Preliminary Design Report Addendum (TII Departure No. 36213)

N2 Road, Ardee (Ardee 2040 Regeneration Project)

April 2025

Title: **STAGE 2 ROAD SAFETY AUDIT**
For;
Main Street Ardee

job number:	drawing number:	revision:
HDC1256	112	08

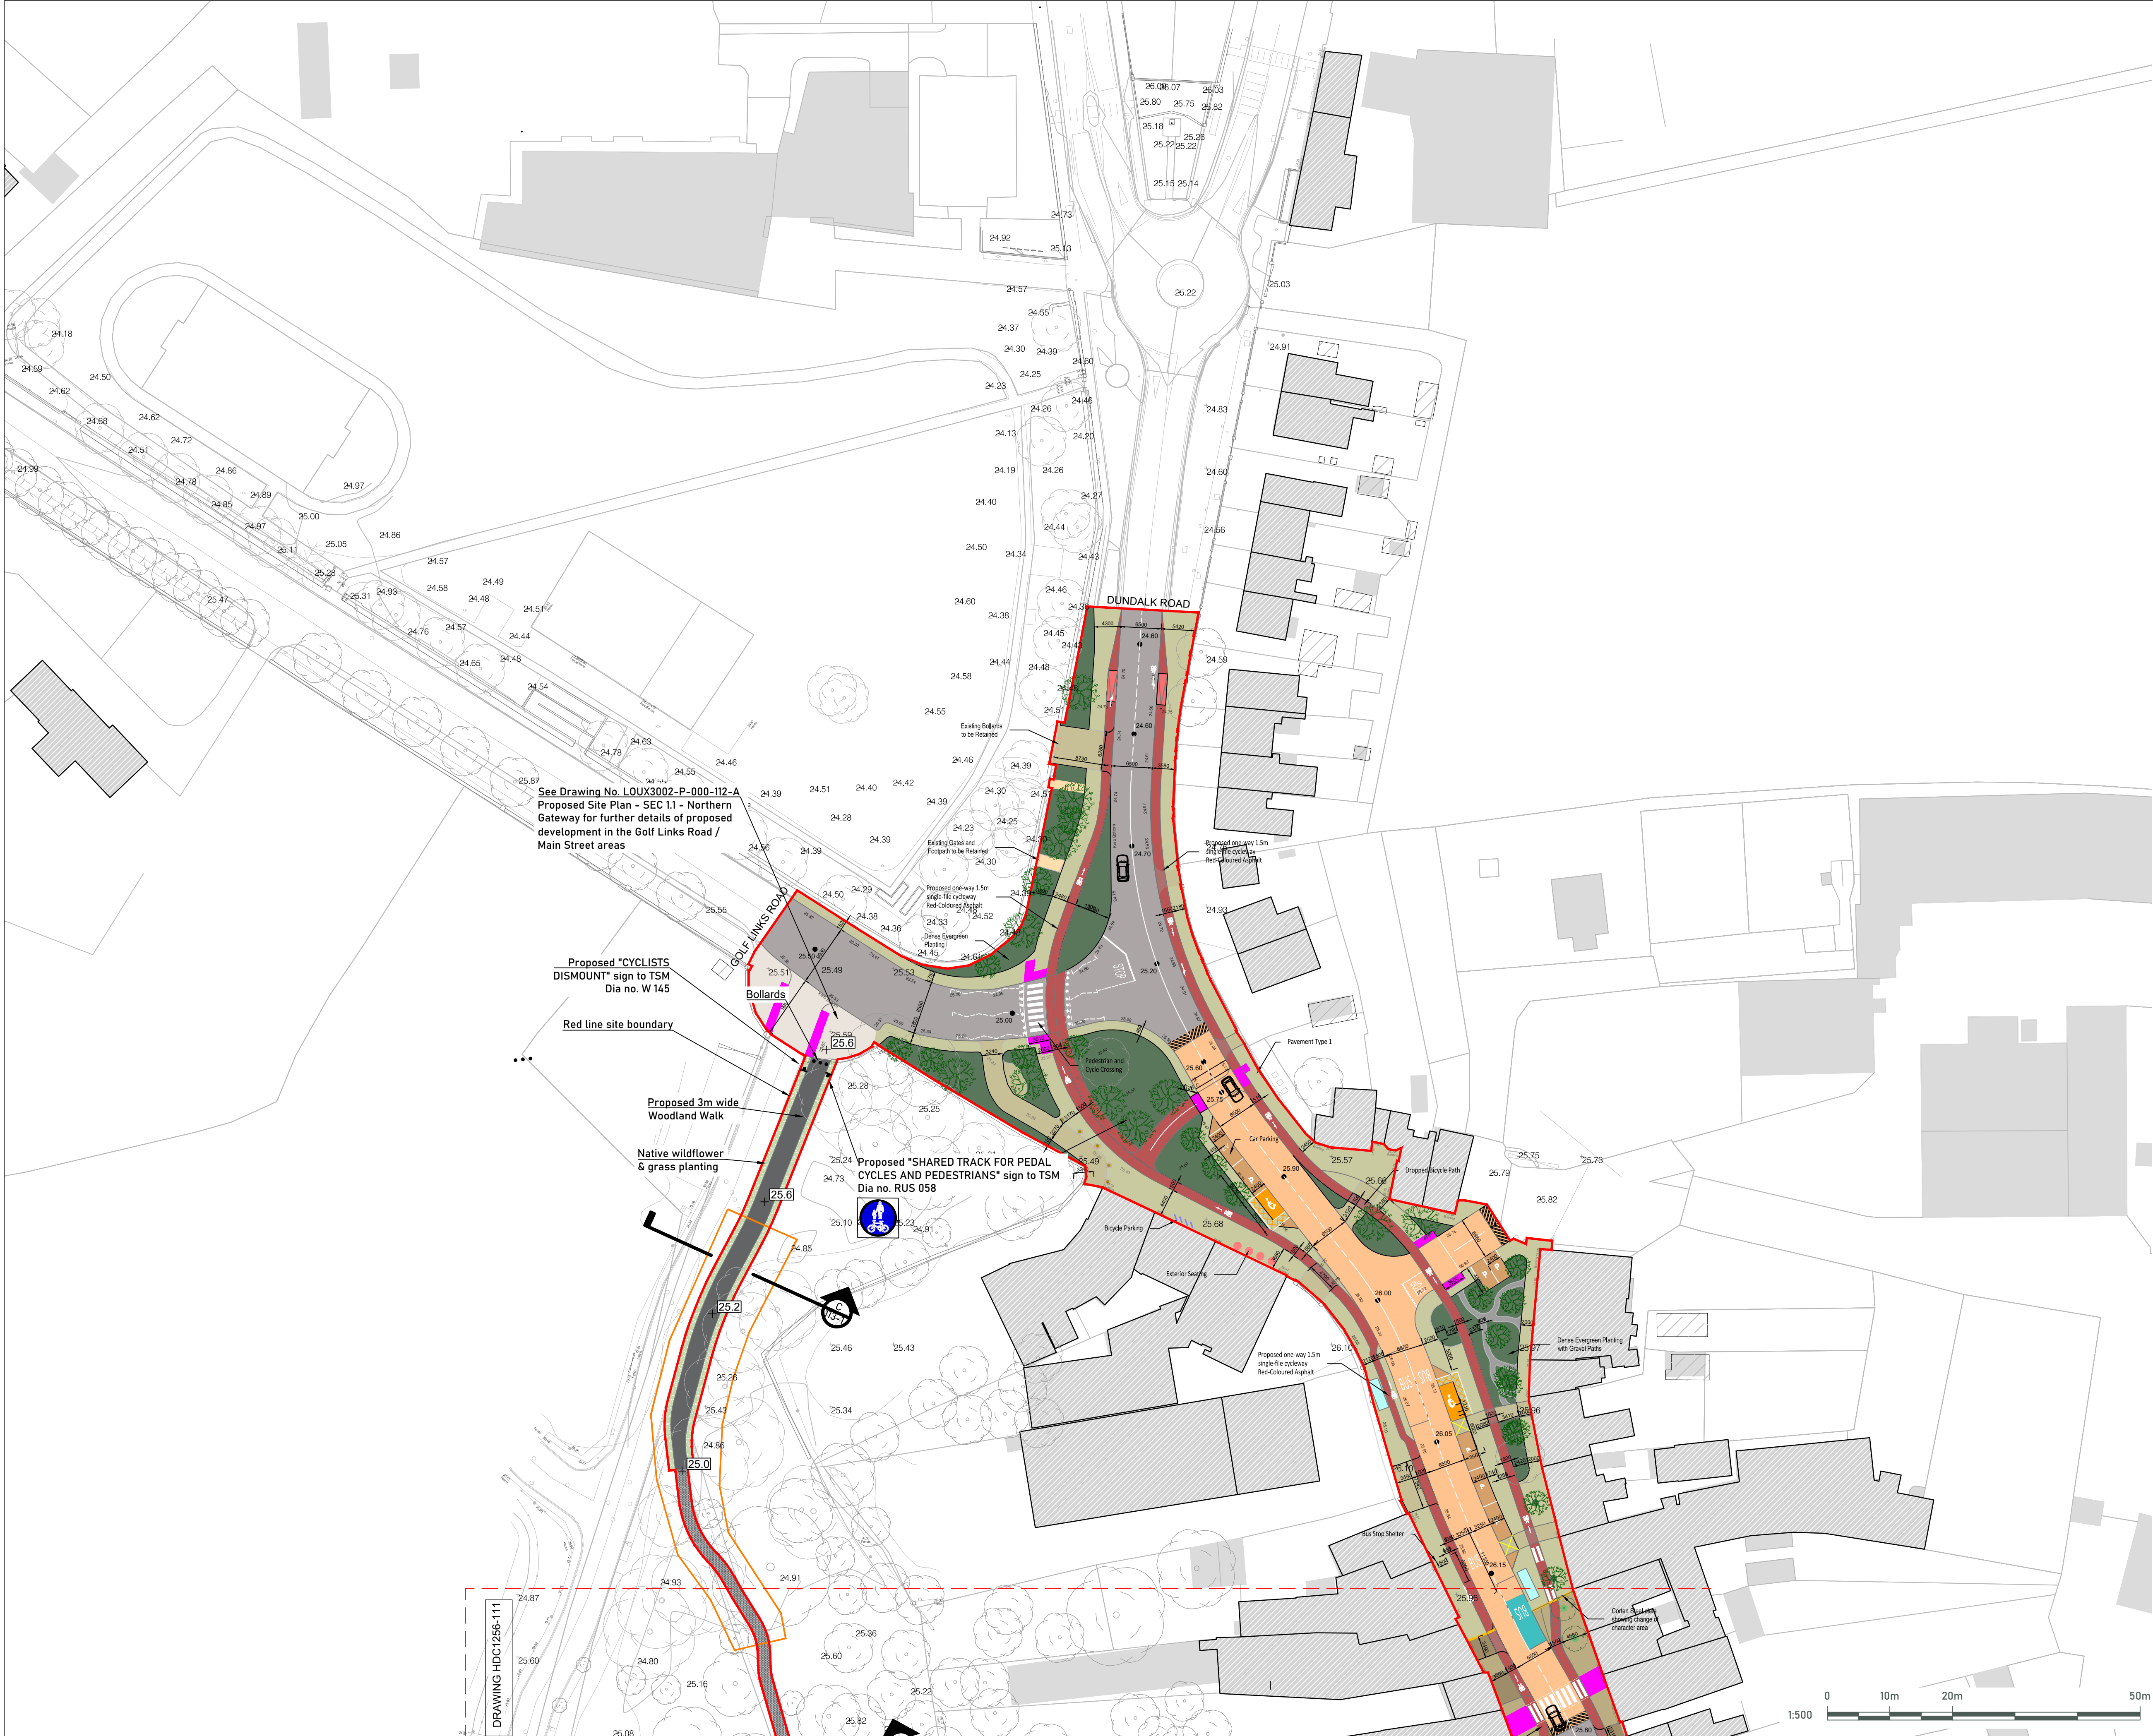
Drawing HDC1256 106 Rev 06, Toucan crossing south of Ash Walk.

The northbound cycle track commences within the L-shaped tactile paving. This area should be shared use and access to the push buttons should be available. The Zebra type road markings should not be provided at toucan crossings as priority may be confusing. A lack of clarity could lead to collisions between vulnerable road users and passing traffic.

Drawing HDC1256 107 Rev 07, South of Dee River bridge.

There is no provision for northbound cyclists to exit the N2 and wait to cross the signalised crossing. Cyclists will therefore continue travelling northbound on the Main Street carriageway thereby increasing the risk of collisions with general traffic. A proposal to direct cyclists via Hale Street was suggested in the Feedback Form of the Stage 1&2 Road Safety Audit. That proposal does not appear to be included in this design update.

Drawing HDC1256 107 Rev 07, Interface of Shared use and cycle only facilities.

A lack of guidance at the interface of shared use and cycle only facilities could lead to blind or partially sighted pedestrians entering a cyclists only area which would increase the likelihood of a collision with cyclists.

Drawing HDC1256 107 Rev 07, South of Dee River bridge.

There is a pinch point in the carriageway south of the bridge. Wide vehicles currently operate an informal shuttle system to pass each other. This may not be possible with the introduction of the new crossing as vehicles may be stuck in position while queuing at the signals. This could lead to side-swipe collisions, damage to bollards and mounting of the footpath. It is noted from the site visit that queuing on the N2 is common for long periods of each day. (It was observed during the most recent site visit that flexible bollards in the footpath at this location have been struck many times and have collapsed)

Drawing HDC1256 107 Rev 07, Pedestrian /cyclists bridge over the River Dee.

The two-way cycle track leads to a shared use area on approach to the bridge. Pedestrians have no area to join the shared use area. This could result in pedestrians crossing the road bridge which has a very narrow footpath and pedestrians would be subject to wind forces from heavy goods vehicles possibly leading to loss of balance.

Drawing HDC1256 107 Rev 07, Car park north of Dee River crossing.

Some proposed car parking spaces appear to be difficult to enter and egress especially if the adjacent spaces are occupied. This could lead to material damage of vehicles or inaccessibility for some users with mobility impairment but not sufficient to be entitled to use the disabled spaces.

It is recommended that a standard layout toucan crossing be provided.

It is recommended that a transition from on-road to off-road be provided for cyclists.

It is recommended that suitable tramline tactile paving be provided at the interfaces.

It is recommended that an analysis be carried out of the likelihood of queues at the pinch point and the possible need for a longer formal shuttle system.

It is recommended that an area be provided for pedestrians to access the pedestrian bridge.

It is recommended that adequate turning space be provided for all car parking spaces.
